DeLUCA-HOFFMAN ASSOCIATES, INC.  
CONSULTING ENGINEERS

August 8, 2011

**Subject: McFarland Spring Corporation  
280 Warren Avenue  
Response to Peer Review Comments**

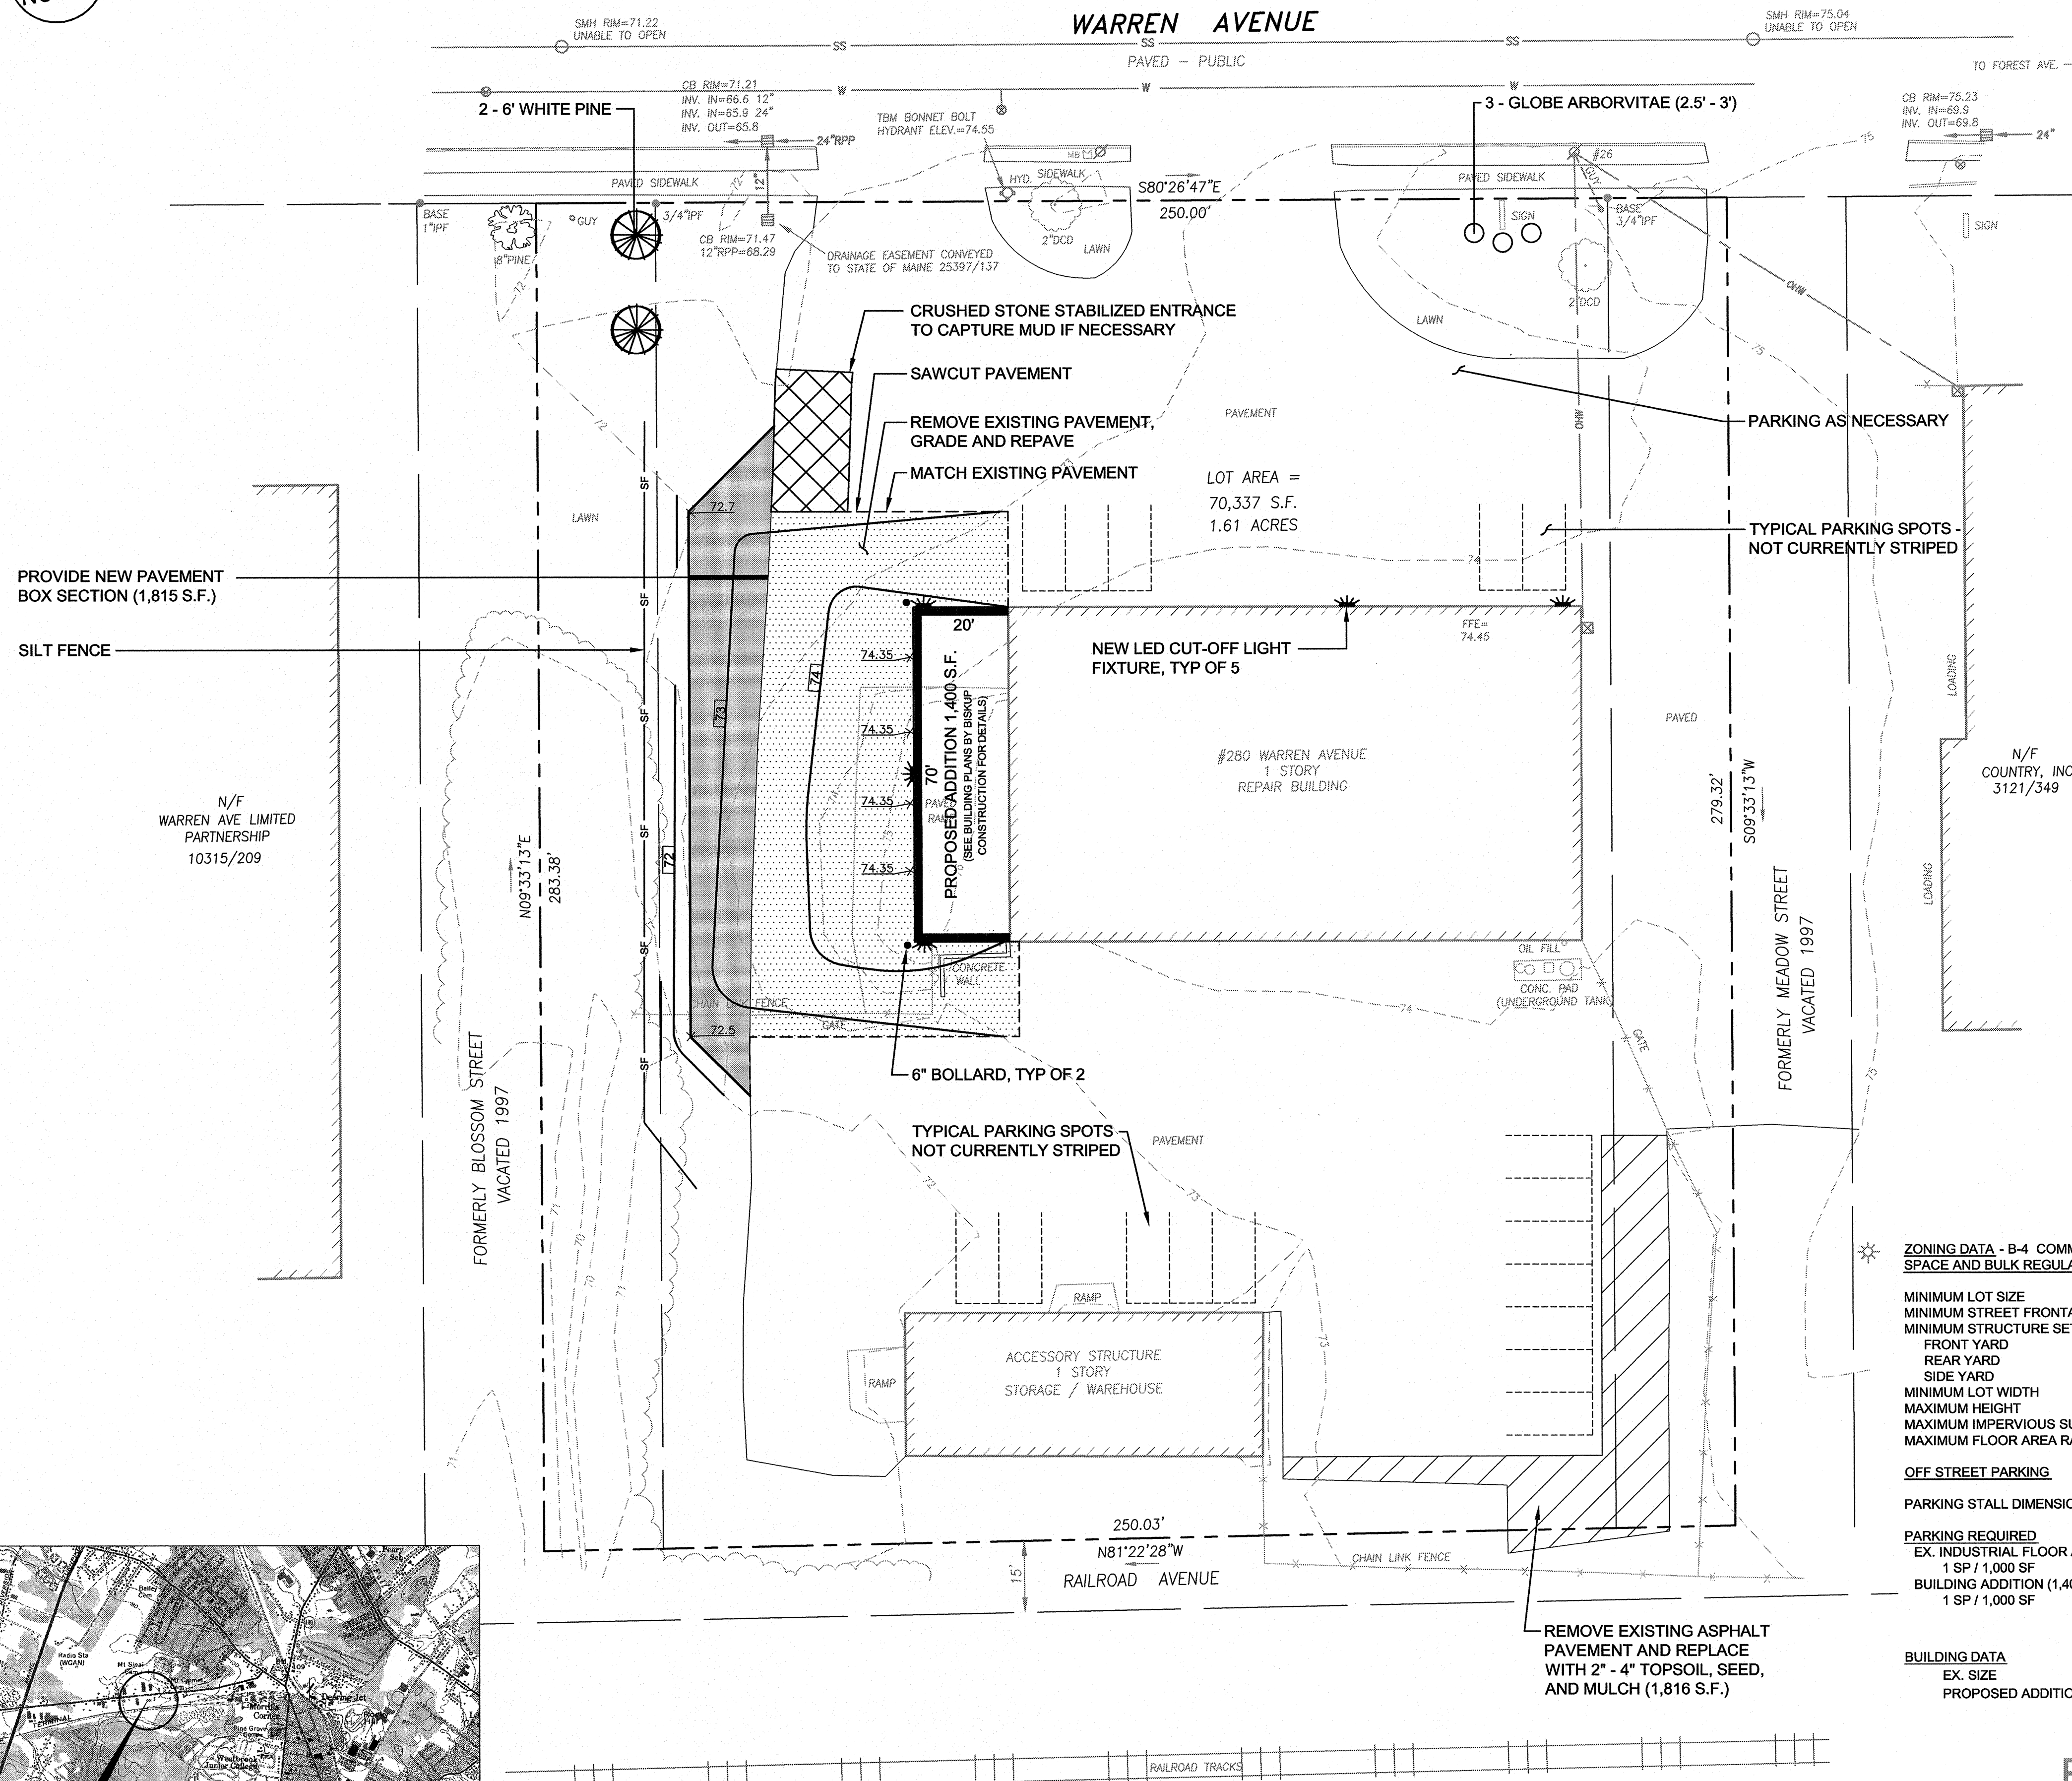
*The submitted text states that 17 or more parking spaces will be provided. The site plan depicts only 12 specific parking spaces. Please revise the site plan to show details (location and dimensions and access drives) of all designated parking spaces; applicable standards are included in the City's Technical Manual.*

*We request clarification as to how the site will work with the business operating and how vehicles will be maneuvered in and out during repairs. Please revise the site plan to show details of the circulation areas, with dimensions.*

*Tree and landscape improvements – Depending on the final driveway access openings to Warren Avenue, additional street-trees should be included along Warren Avenue frontage as space allows and/or add trees to the space along the right property line. This should be between the front building plane and street. These trees may be shade or evergreen trees.*

*Create a small landscape planting along the front of the building expansion. This could be similar to 'foundation' planting along the building using hardy shrubs. The planting may be protected by 'Cape-Cod' style bituminous, concrete or granite curbing as desired by the project or wooden guardrail. This small planting adds relief to the large paved areas and building.*

*Per Section 5 of the City of Portland Technical Manual, Level II Site Plan Applications are required to submit stormwater management plans pursuant to the regulations of the Maine Department of Environmental Protection (MaineDEP) Chapter 500 Stormwater Management Rules, including compliance with the Basic, General and Flooding Standards. A stormwater management plan was not provided in the application, and the Applicant has requested a waiver from this requirement. We cannot support a waiver from this requirement. One suggestion provided during consultation with the City Department of Public Services is that the Applicant can elect to eliminate (change to pervious) an existing on-site impervious area of equal or greater size to the proposed new impervious area, and effectively meet the General and Flooding Standard.*

The accompanying revised site plan indicates the locations of parking available across the site. Generally speaking, the parking varies across the lot depending on the flow of business and daily demands of customers. Based on the capacity of the business and number of employees, the owner finds that parking availability has not been a concern, as they have ample area on which to park. No permanent pavement markings are in place on the site and the owner requests the right to maintain the existing conditions with respect to how parking functions. The accompanying plan simply outlines the available parking capacity and maneuvering areas on the site.

The accompanying figures depict the general site circulation patterns. The owner has operated the existing facility for a significant period and they have never experienced concerns with site access or circulation.

The accompanying site plan includes multiple new landscape plantings along the Warren Avenue frontage that are provided to meet the general intent of the City's review comments. The plantings are located within the existing areas not otherwise used for the storage of snow during the winter.

The applicant requests a waiver to provide landscaping along the building foundation as this area will be prone to roof runoff and within the area of general business activity around the perimeter of the building. It is the applicant's opinion that a planting area adjacent the building will not survive and will inhibit their functional use of the surrounding paved areas. Alternatively the accompanying plan includes plantings located to meet the intent of the review comment.

To satisfy the standards, we have modified the site plan to eliminate approximately 1,814 SF of existing impervious surface on the site in order to offset the proposed impervious areas depicted on the site plan.
